**From:** [Kerren Ven](#)  
**To:** [Rebecka Groth](#)  
**Subject:** RE: SSD-10436 MOD 4 - Amendments to Lot 204 (formerly Lot 203)(SSD-10436-Mod-4)- Reminder of Due Date for Response to Planner  
**Date:** Monday, 21 March 2022 11:38:30 AM  
**Attachments:** [image009.png](#)  
[image004.png](#)  
[image005.png](#)  
[image018.png](#)  
[image020.png](#)  
[image021.jpg](#)  
[image022.jpg](#)  
[image023.jpg](#)  
[image024.png](#)  
[image026.png](#)

Council's Traffic Branch has reviewed the proponents Traffic response letter dated 1 Feb 2022 and advise the following matters must be addressed in order to satisfy the site servicing arrangements:

Figure 6 | Proposed Lot 204 Site Plan (new truck entry/exit point identified in red)

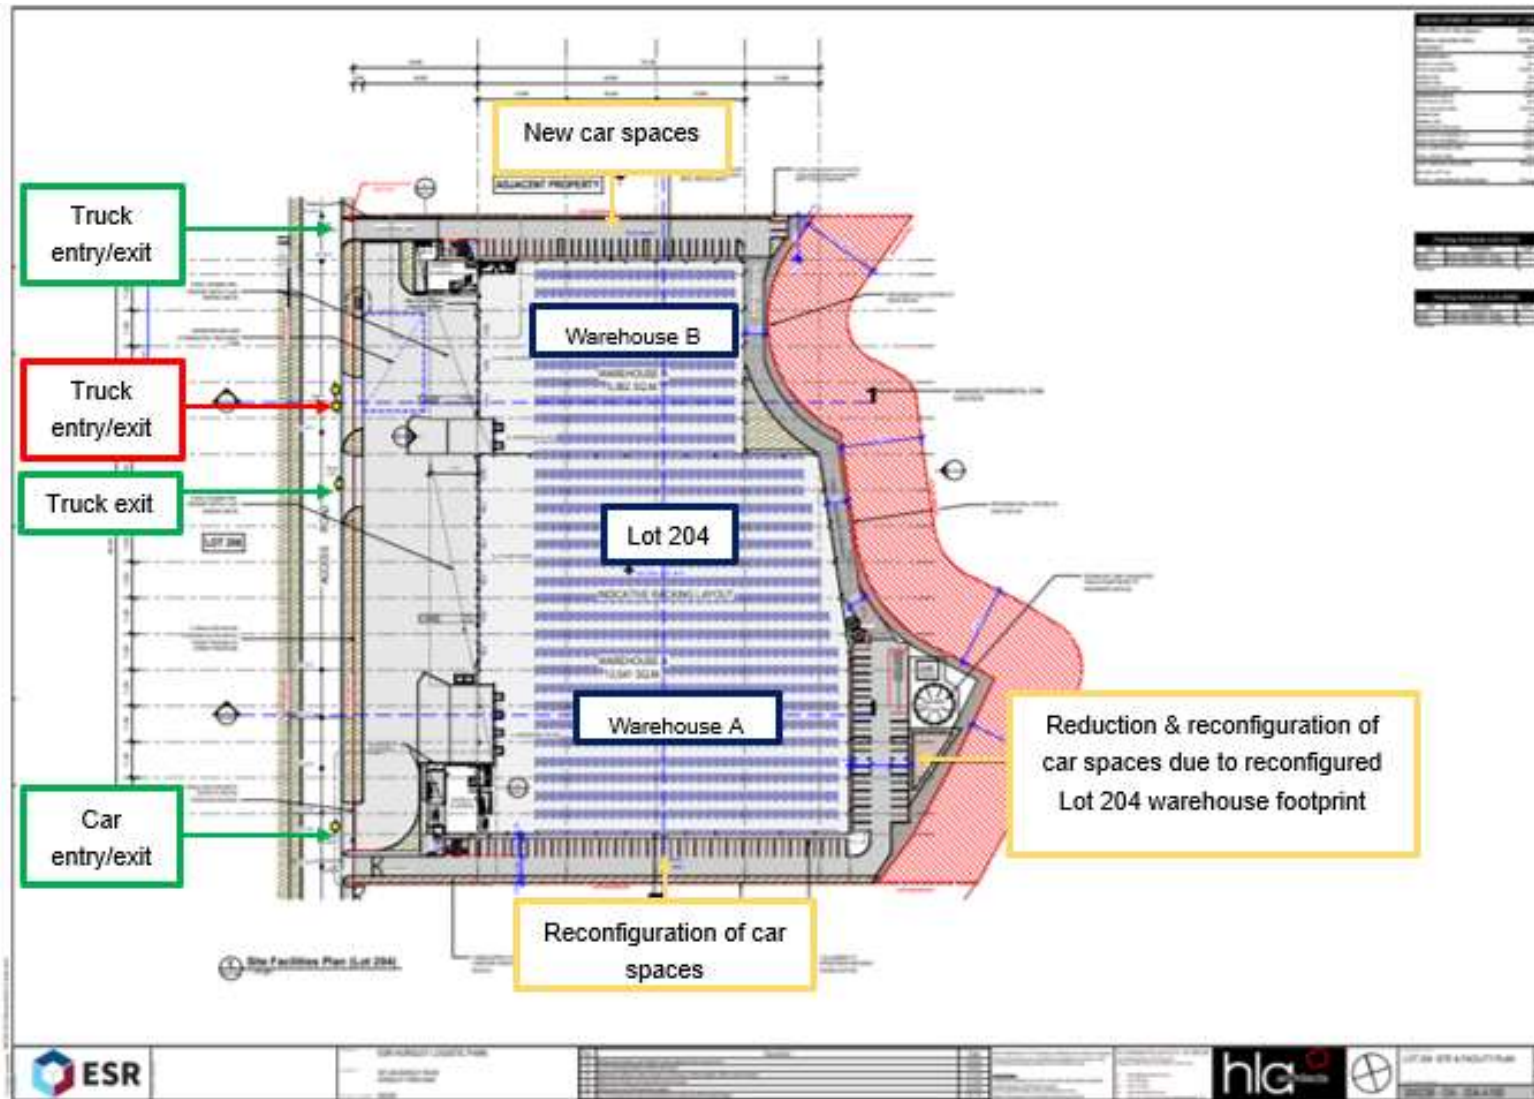
1. The applicant has not provided swept path diagrams to demonstrate that 19m vehicles can satisfactorily manoeuvre within the site when the recessed docks are occupied by heavy vehicles. In addition, the applicant has not provided information in relation to how truck movements into, within and out of the site will be managed i.e. whether there will be any traffic management measures to prevent trucks from entering the site when all of the spaces in the loading docks are occupied. This will ensure that there will not be internal manoeuvring issue consequently minimising traffic impacts on the adjoining external road network.

A loading management plan shall be submitted to Council for assessment. Otherwise, this can be incorporated into the conditions of the development consent.

2. The site does not make provision for a loading bay to accommodate 26m B-Double vehicles. Swept paths indicate that that a 26m B-Double vehicle manoeuvring within the site will be impacted by heavy vehicles parking at the recessed docks. Loading and unloading activities shall occur within the designated loading area in order to not obstruct the flow of traffic within the site.

An Operational Traffic Management Plan and Loading Dock Management Plan shall be submitted to Council for assessment prior to the issue of a Construction Certificate.
